Sydney Olympic Park Authority Site 4B- Design Review Panel Response

24-Aug-06	DRP Issue No:	Design Issue	Design Response	Reference
	1	>The maximum number of brush box trees should be retained and integrated into the new landscape setting of the building. The ground plane, plantings and the interface with the adjoining uses should clearly defined the open space.	four Brush Box have been retained forming a segment of the arc and strengthening the view to the heritage precinct over Herb Elliot Avenue. The levels of the T.S.L have been designed to address equal access throughout, as well as maximising the flush ground level transition from inside the building to be T.S.L.	26045-LP01
	2	>The space between the buildings has been squeezed by the location and bulk of the lift core. It presents an imposing and unwelcoming address to the building from both street frontages but particularly Olympic Boulevard.	>The bulk and solidity of the core has been reduced by introduction of glazing and open plan areas to improve the transparency between atrium and public open space.	Architectural Design Report

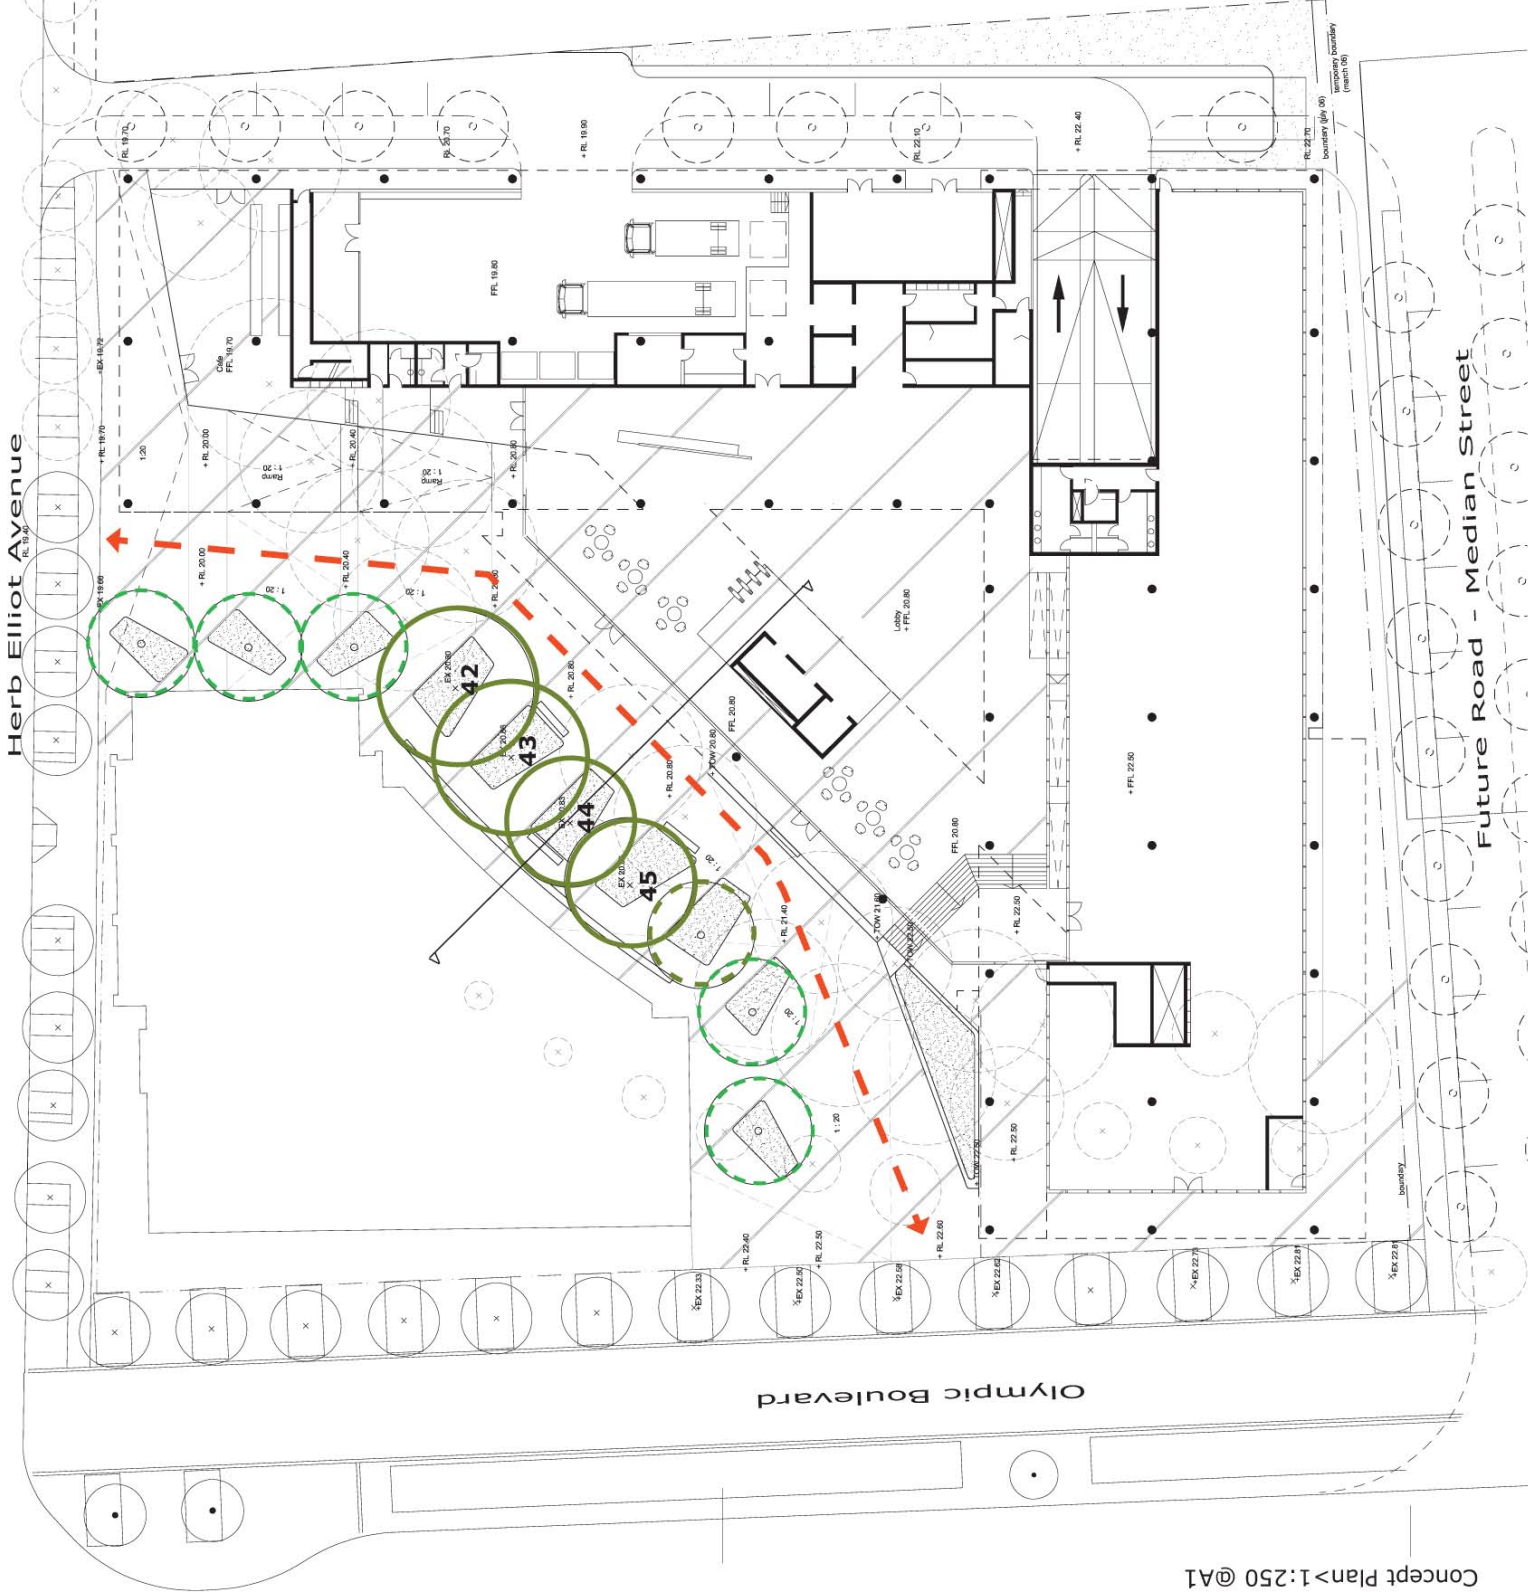
8	>The colour palette of the glass and the terracotta elements should be developed in a considered relationship with the Sofitel and CBA buildings to Herb Elliot Avenue	>Relationship achieved through the following: horizontal architectural expression • articulated planar building forms • single and double storey colonnades • external horizontal sunshades • defined entry statement • mixed-mode expressed break-out nodes to address campus buildings • blue-green glass • proposed charcoal terracotta matches the horizontal spandrel of the Sofitel and CBA campus buildings	• AR-SK-03
	9	>The landscape treatment should read as a continuation of the public domain, not as a private courtyard of the new development.	The main surface treatment is concrete unit paving specified in the VEDM. This ground plane treatment signifies the T.S.L as a continuation of the P.D. Other P.D elements will be in accordance with SOPA guidelines (light, benches, and bins) as required.	26045-LP01

17	>The pavement should blend seamlessly with adjoining streets and public domain, not impose a different overlay.	The pavement design has been adjusted. The current proposal is to retain and upgrade the existing pavement on Australia Avenue and Herb Elliot Avenue	26045-LP01
18	>The continuity of the colonnade between the streets for the benefit of pedestrians is to be considered.	An 1800mm deep colonnade has been introduced adjacent to the atrium to allow for a continuous covered area for pedestrians along the building edge between Herb Elliot avenue and Olympic Boulevard.	26045-LP02
19	>The contiguous ground plane between the outdoor space and the lobby. Please verify this can be achieved without compromising trees and paths of travel	The lobby level has been dropped to match the RL's of the existing trees. This achieves a consistent level transition between the public domain and the lobby.	26045-LP02

Concept Plan > 1:250 @ A1

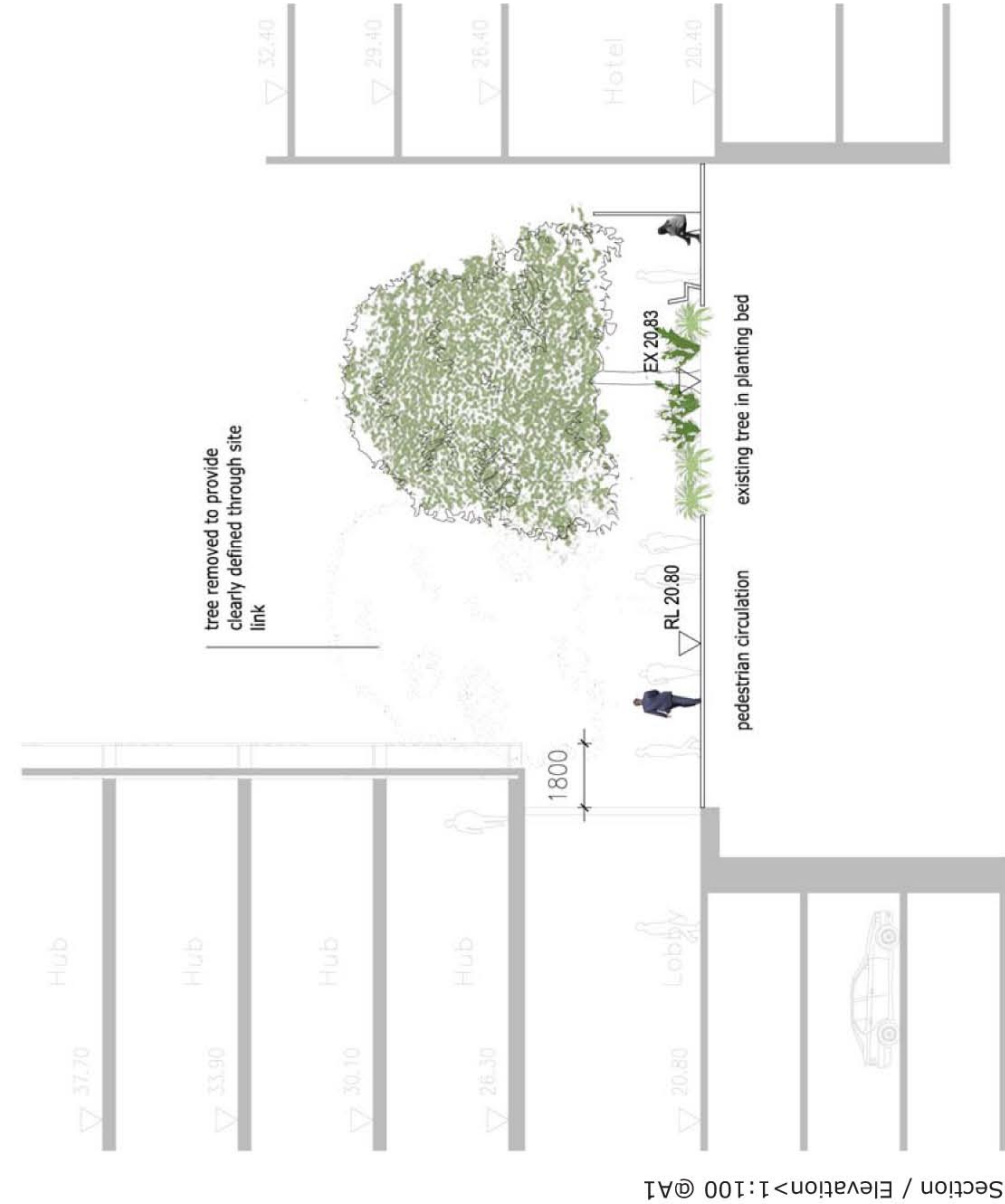
14	>Tree selection should not compete with Boulevard planting. Should be distinct and separate space with different identity to streets. Relationship is to Maiden Gardens and Heritage precinct	The tree's selected for the T.S.L are Toona sinensis - the Chinese Toona which is a light canopied, light foliage spreading tree. In contrast to the Hoop Pines on Australia Avenue, the Toona are a deciduous tree (specified to allow light into the T.S.L) and relate in scale and form to the plantings in the Maiden Garden	26045-LP01
15	>The location of the glass line to the lobby- DRP questioned whether this still could be pulled back?	The glass line to the lobby has been pulled back to create a covered walkway.	
16	>The limited amount of tree planting. This is a pedestrian scale space that needs an appropriately scaled and intimate canopy and ground plane.	As noted in point 14, the Toona are a light but spreading canopy which will form a connected canopy at a level allowing views through and maintaining safety and surveillance. The 6 new trees will compliment the 4 existing Brush Box. The lush understorey planting is approximately scaled for a pedestrian T S L	26045-LP02
